Application No: FG/163/21/PL
Site Address: The Chalet Littlehampton Road Ferring BN12 6PG
Description of works: Development comprising of marine workshop & boatyard, martial arts gym (Class E) & storage container compound (Class B8) to replace former glasshouses. This site is a Departure from the Development Plan & is in CIL Zone 3 (Zero Rated) as other development.

Sussex Area Ramblers Association
Planning Consultation Response
To Development Control, Arun District Council

Arun DC Planning Application FG/163/21/PL
The Chalet Littlehampton Road Ferring BN12 6PG
Proposed marine workshop & boatyard, martial arts gym (Class E) & storage container compound (Class B8) to replace former glasshouses.

SITE PLAN 1:500 @ A3

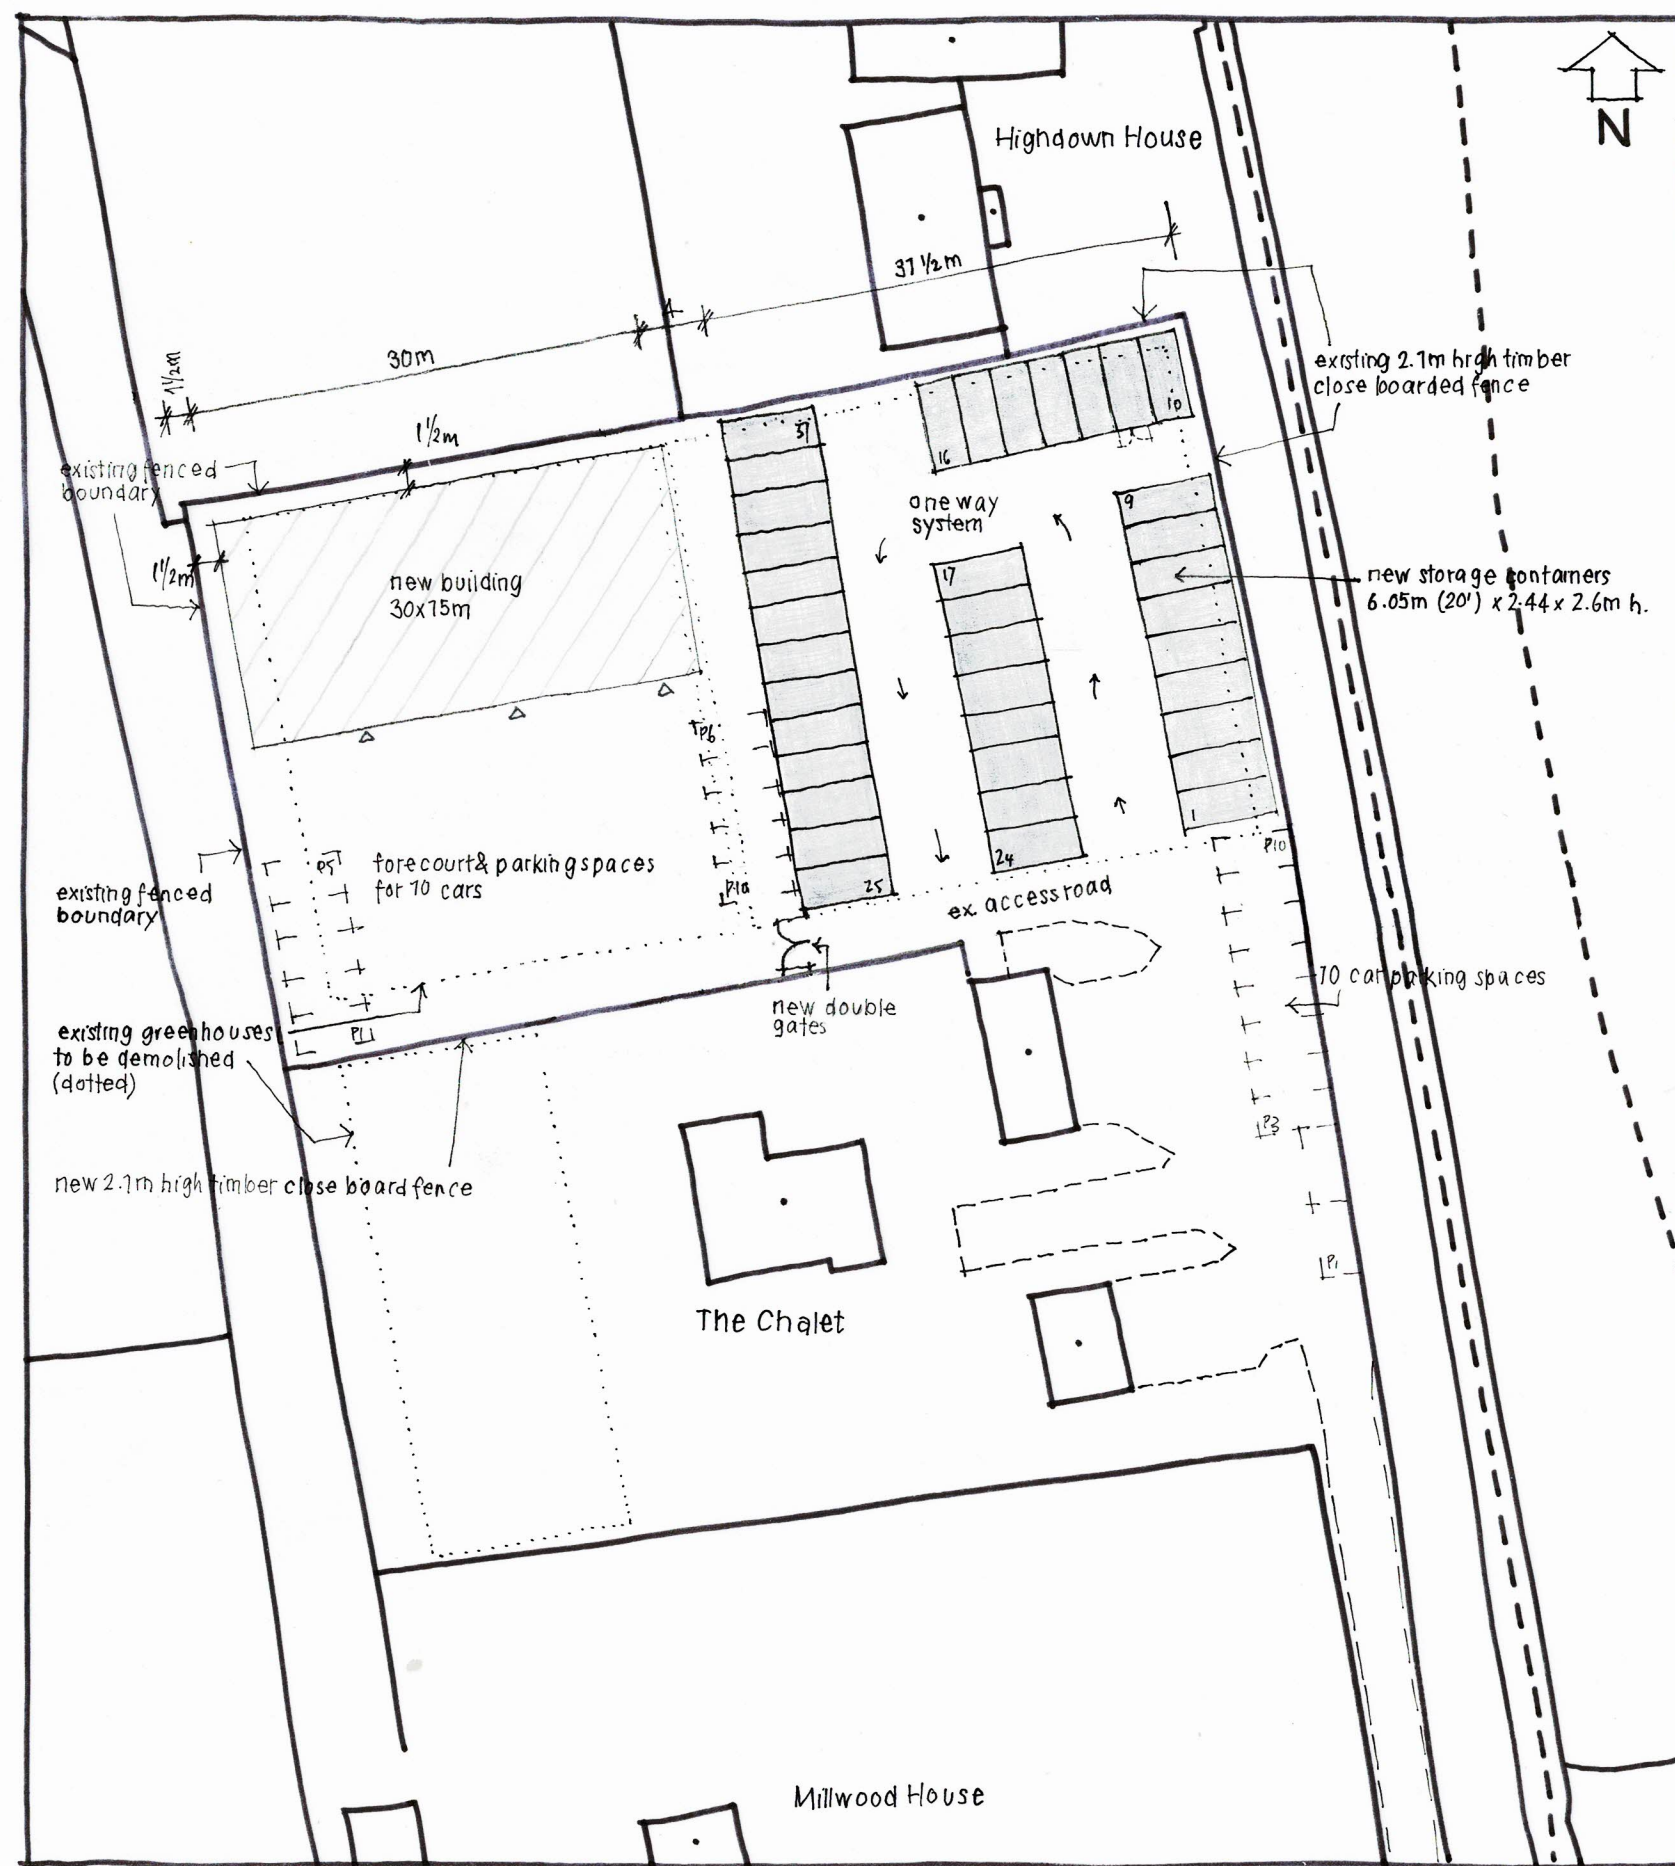
The proposed new building and storage units immediately abutting Public Bridleway 2135 would appear as a rather unsympathetic replacement of the glasshouse, and which in the absence of any mitigating landscape treatment would have an adverse impact on the walking environment. For this reason we object to the proposals.
